From: Chris Jones [REDACTED] >
Sent: 13 May 2025 09:39
To: Iqraa Malik
Subject: RE: Request for further information R/80/25/HH
Attachments: Stanmore prop 1 block.pdf

From: Iqraa Malik <[REDACTED]>
Sent: 13 May 2025 09:26
To: Chris Jones [REDACTED] >
Subject: RE: Request for further information R/80/25/HH

PROPOSED BLOCK PLAN SCALE 1:500

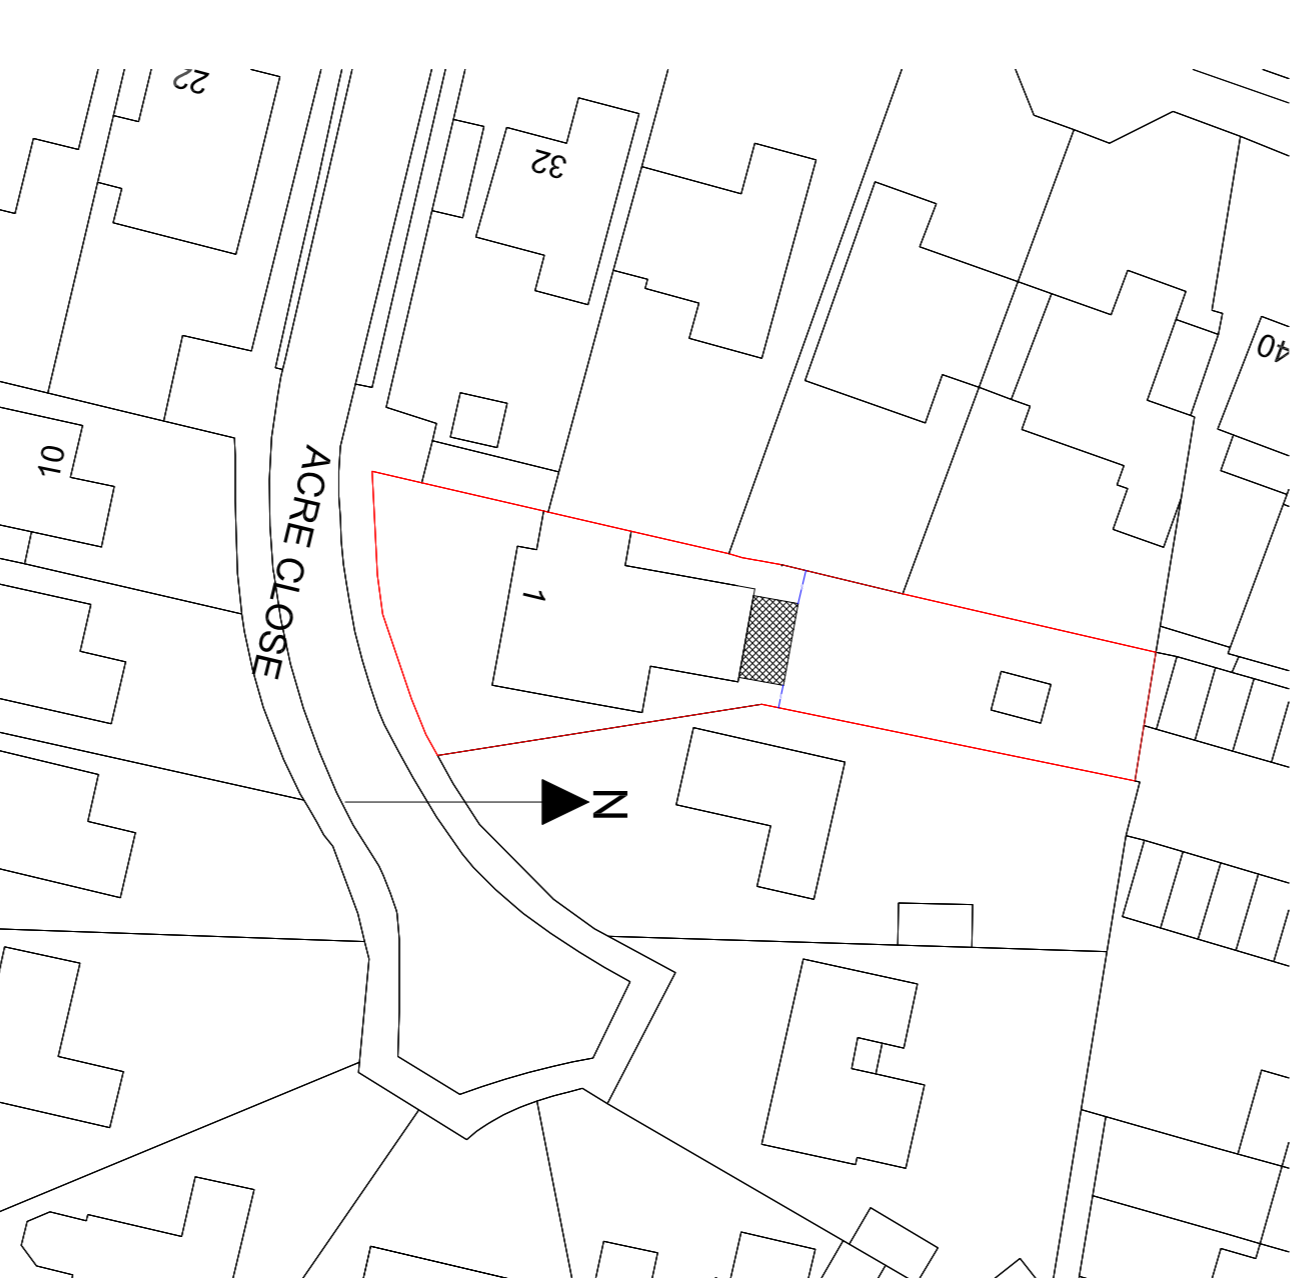
Could you please add the dimension to the rear boundary? That is the one that is outstanding.

Unfortunately, this application is still invalid as the block plan also requires the dimension from the proposed extension to the rear boundary. Please review and amend.

Hi Iqraa,
Please see attached large scale block plan showing distances to boundaries. I hope this is ok? It's the best I can do. If it isn't please can you send me an example of what you require?
